Consultation Response from: KC Environmental Health (Pollution & Noise Control)		
2020/90640 - Holmfirth High School, Heys Road, Thongsbridge, Holmfirth, HD9 7SE		
Formation of artificial grass pitch with associated features, including eight 15m high floodlights, fencing up to 4.5m, pedestrian circulation and access route, vehicular maintenance and emergency access with Springwood Road, erection of store, grass mounds, retaining structures and landscaping works		
Date Responded: 04 May 2020	Responding Officer: Richard Hume	Responding Ref: WK/202006877
Noise A “Noise Impact Assessment Report” by Acoustic Consultants, dated 10 Jan 2020 (Ref: 8082/DO) has been submitted. The report predicts the noise levels that will occur at nearby noise-sensitive properties by using measurements of noise from sports activities at existing similar sports facilities and compares those levels with measurements of the existing noise levels within the site. It advises that the proposals are for the development to be open for use, including use by the community, from 9:00 until 22:00 Monday to Friday and until 17:00 on Saturday, Sunday and Bank Holidays. The assessment predicts highest noise level at the

Project maintenance factor
0.90

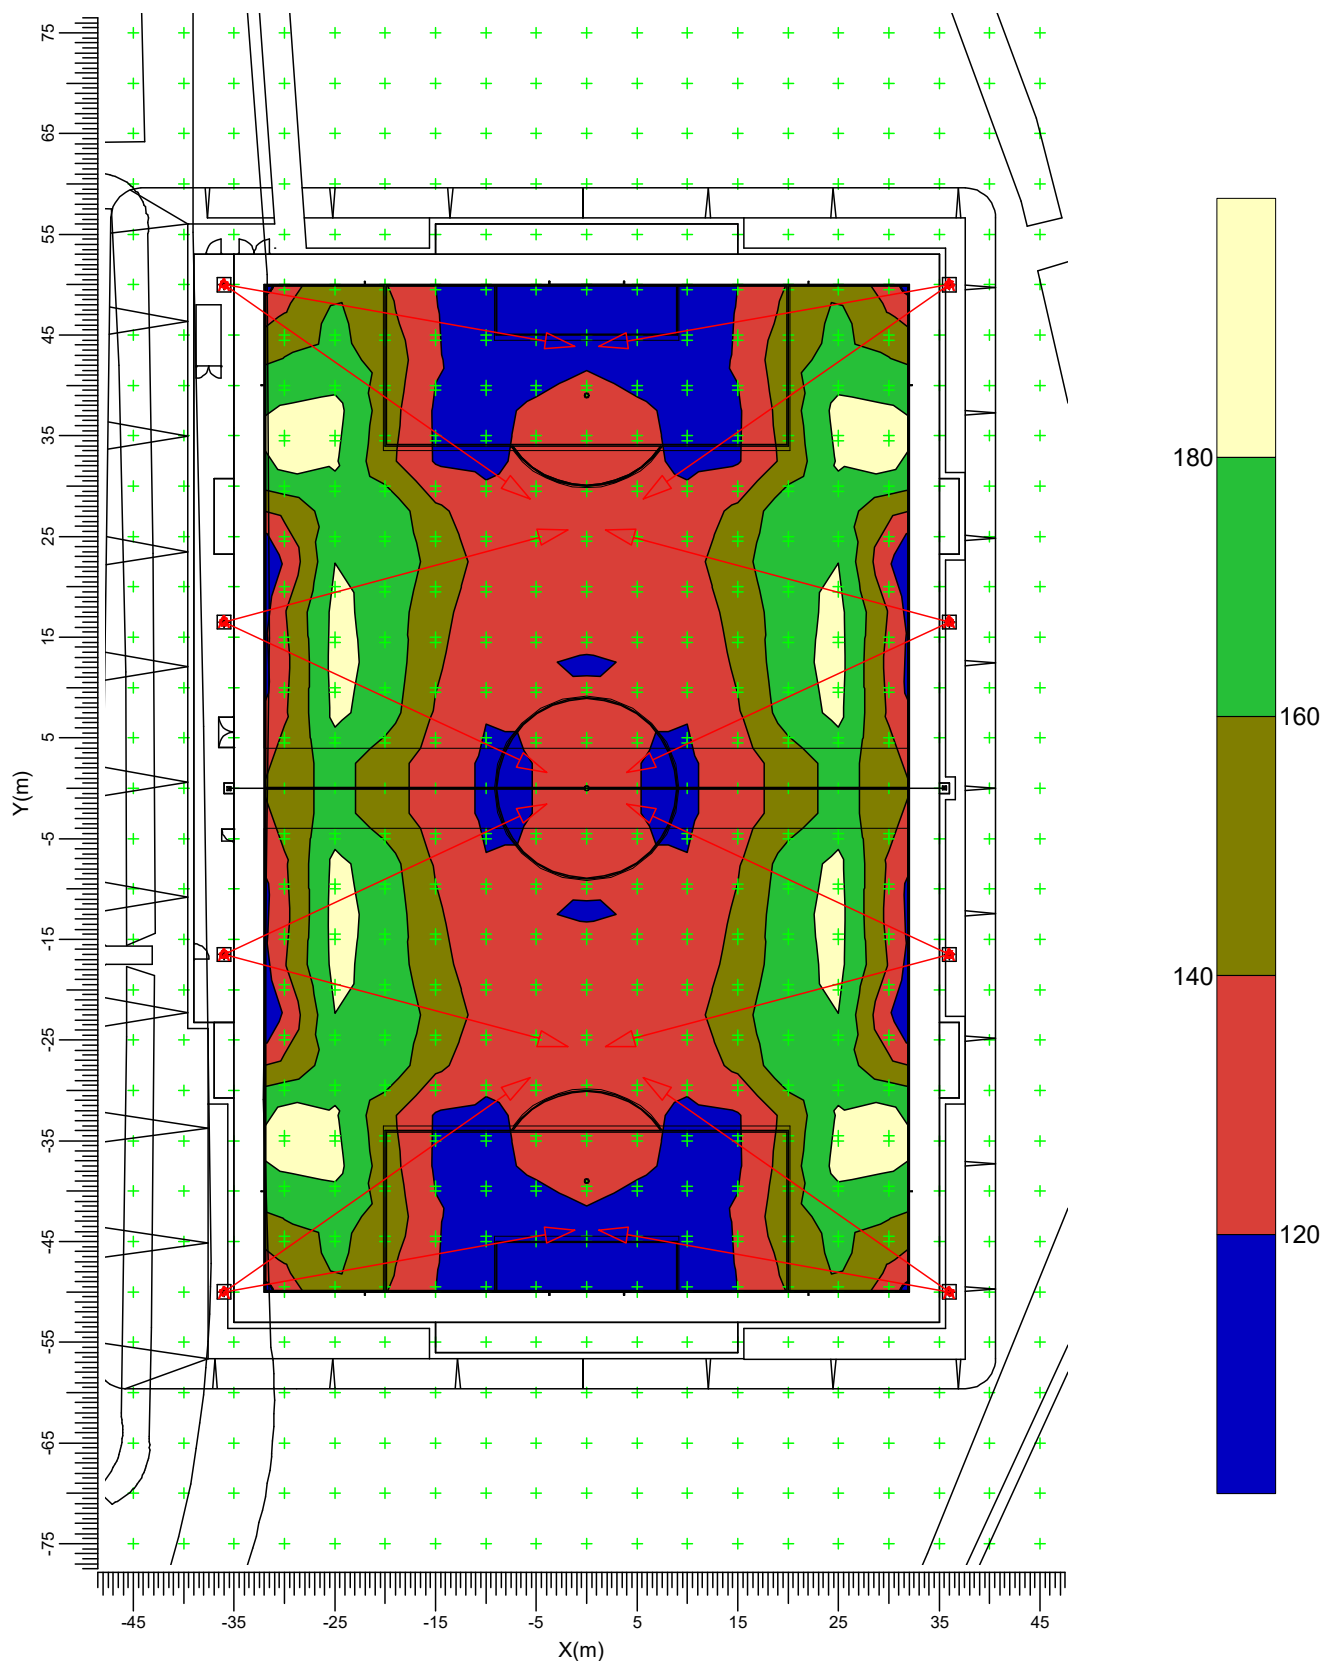
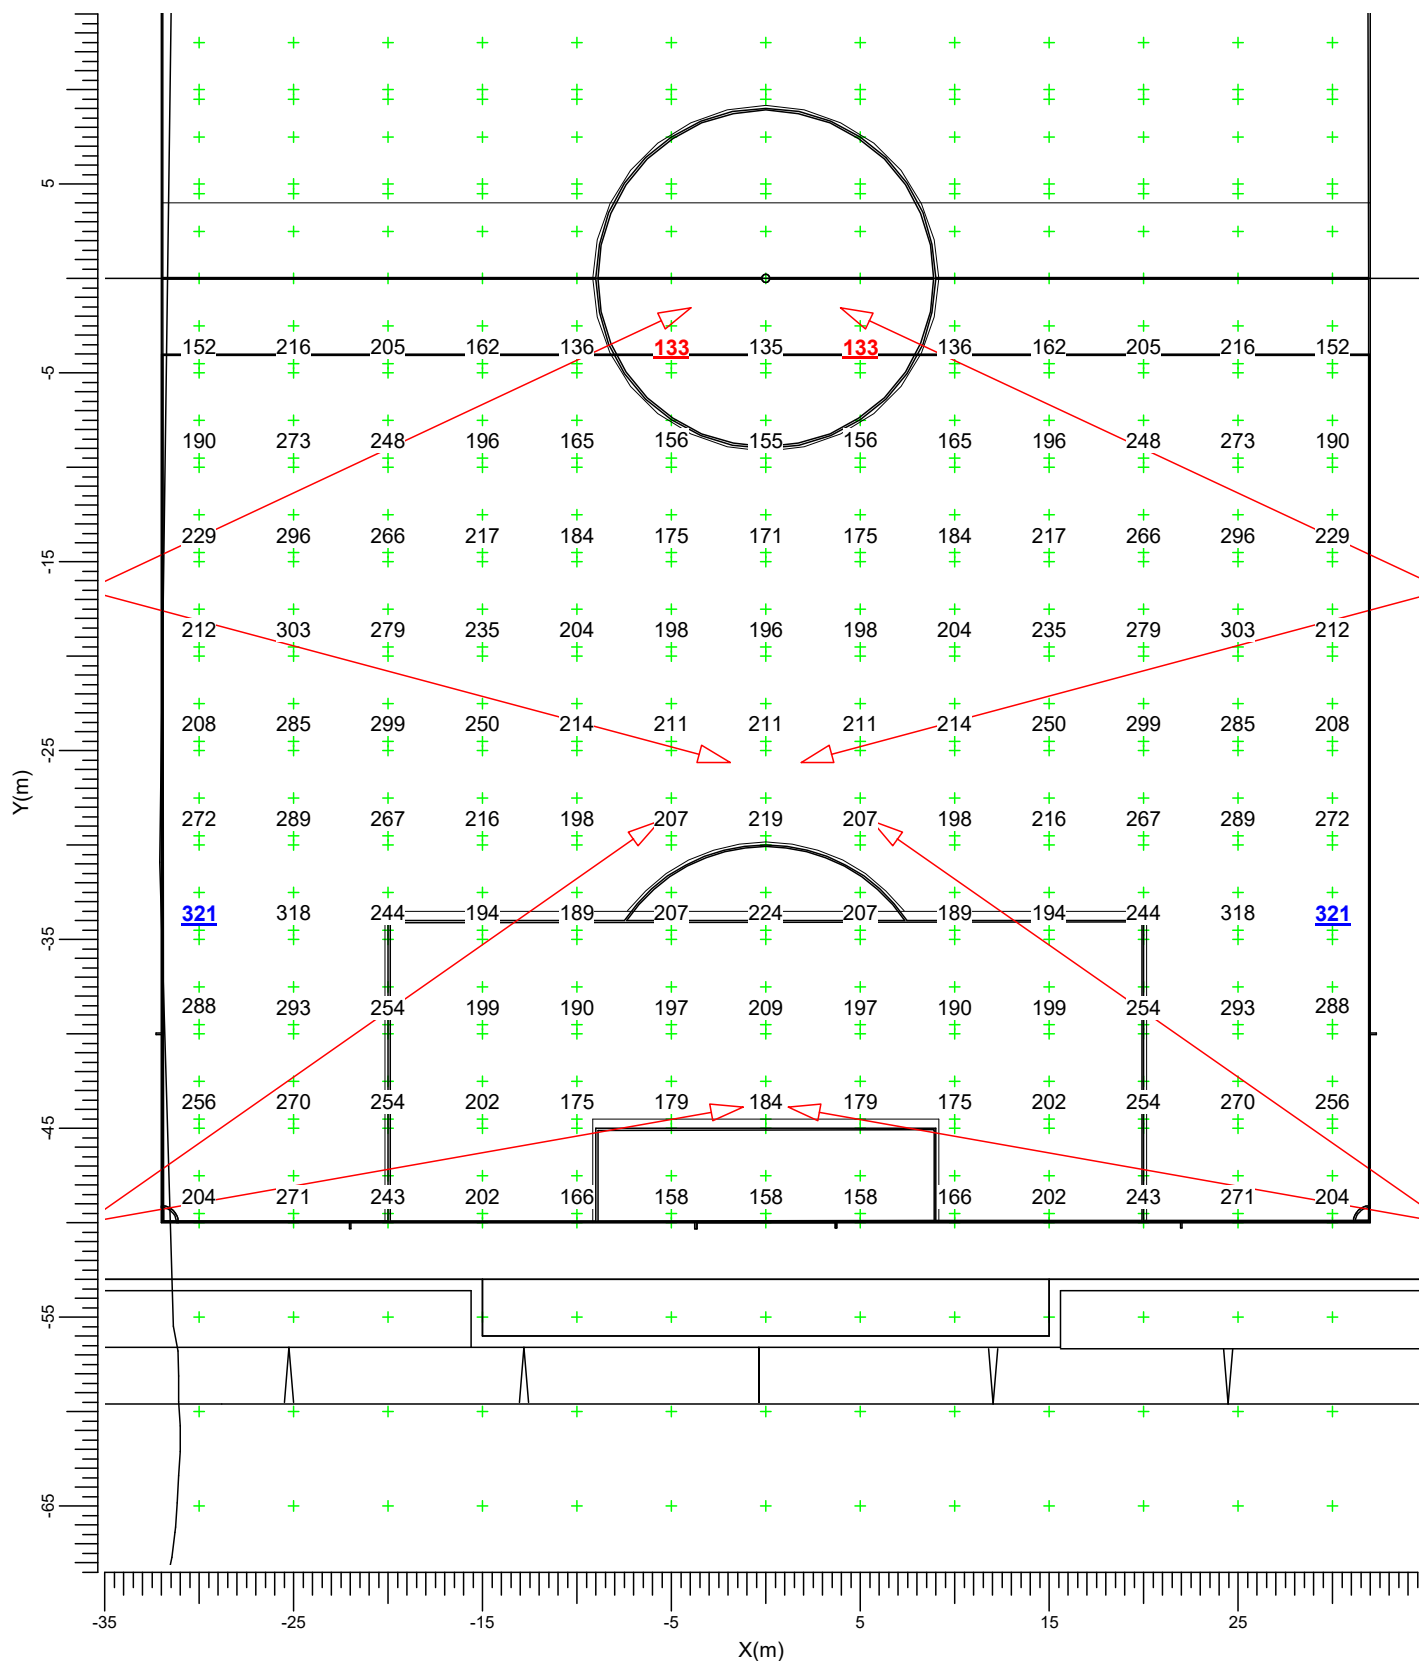
The design levels of illuminance for the pitch are 120 / 200 lux based on football association guidance, and reference is also made to BS EN 12193. The lighting proposals predict that the maintained average illuminance will range from 142 to 237 lux for the whole pitch and 221 lux for when half the pitch is lit, based on a maintenance factor of 0.9. The report indicates, from spillage at ground level and at 1.8m illuminance information, that the proposed lighting will cause illuminance levels of less than 1 lux at nearby residential premises except for 46 Springwood Rd where it predicts it will be 1.38 lux. It is unclear from the information provided, but it is assumed these levels refer to horizontal illuminance. It proposes that the lighting will remain lit for 15 minutes after the pitch use ends, to enable safe egress for users.

There are some concerns regarding the proposed and predicted levels of illuminance. The football association guidance which has been used for the design levels of illuminance is intended for lighting installations for Clubs wishing to compete in FA competitions and in the National League System. The British Standard referred to in the submitted document (BS EN 12193 (2018) Light and Lighting - Sports Lighting) provides different guidance, recommending illuminance levels of 75 lux for a development of this type.

I therefore consider that the proposed illuminance levels are significantly higher than are necessary for the intended future use and therefore unacceptable. A condition requiring revised proposals for the artificial lighting are therefore necessary.

Before the installation of external artificial lighting commences, a lighting scheme shall be submitted to and approved in writing by the Local Planning Authority. The scheme should include the following information:-

- a) The proposed hours of operation of the lighting
- b) The location and specification of all of the luminaires
- c) The proposed design level of maintained average horizontal illuminance for the areas that needs to be illuminated.
- d) The predicted vertical illuminance that will be caused by the proposed lighting when measured at windows of any properties in the vicinity.
- e) The measures that will be taken to minimise or eliminate glare and stray light arising from the use of the lighting that is caused beyond the boundary of the site
- f) The methods of switching and controlling the lighting so that it is only operated at the permitted times and at times when it is required.
